**Consultation Response from KC,
Highways Development Management**

2024/92848 Marsh Carpets, 82-84, Westbourne Road, Marsh, Huddersfield, HD1 4LF

Date Responded: 25-11-2024.

Responding Ref: 5-2SE-7.

Drawing:  
**Proposed Floor Plans**

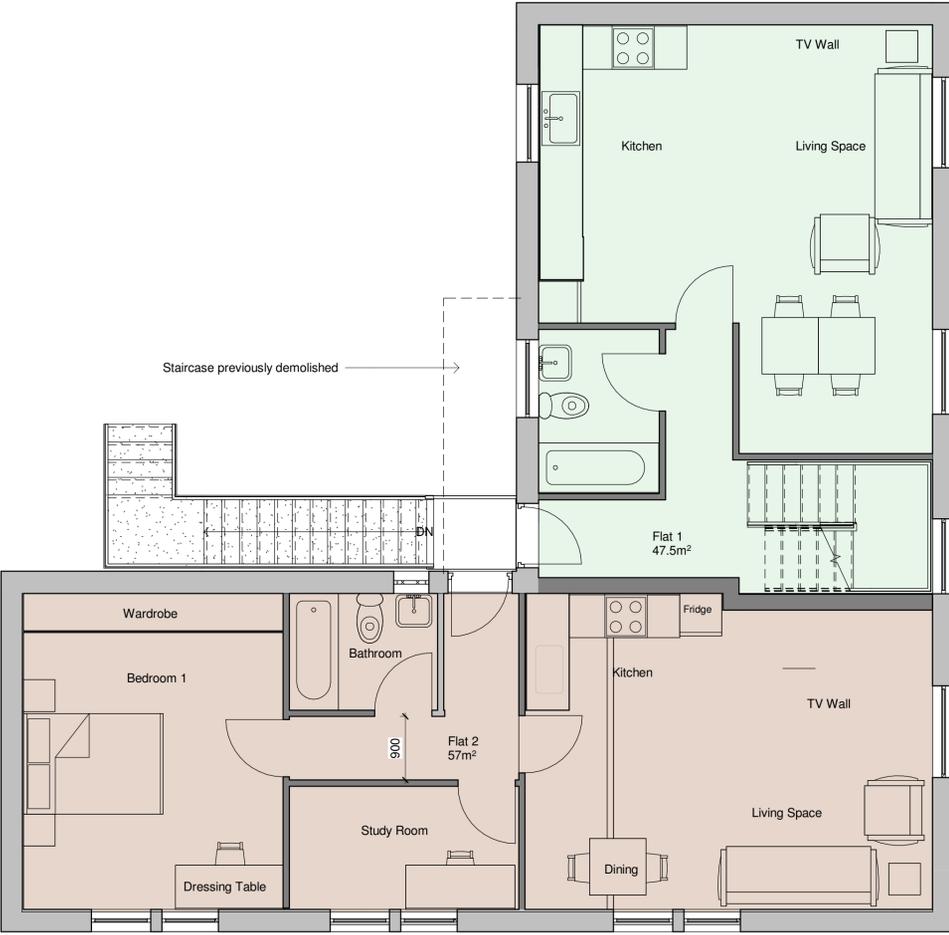
Two existing parking spaces and a bin store are shown to rear of the premises with access from Abb Street.

This application however provides insufficient information.

The proposed shops fronting onto Westbourne Road have no rear access to the proposed bin store and no details are provided regarding the proposed bin presentation points. Highways Development Management would not want to see bins on the Westbourne Road footway.
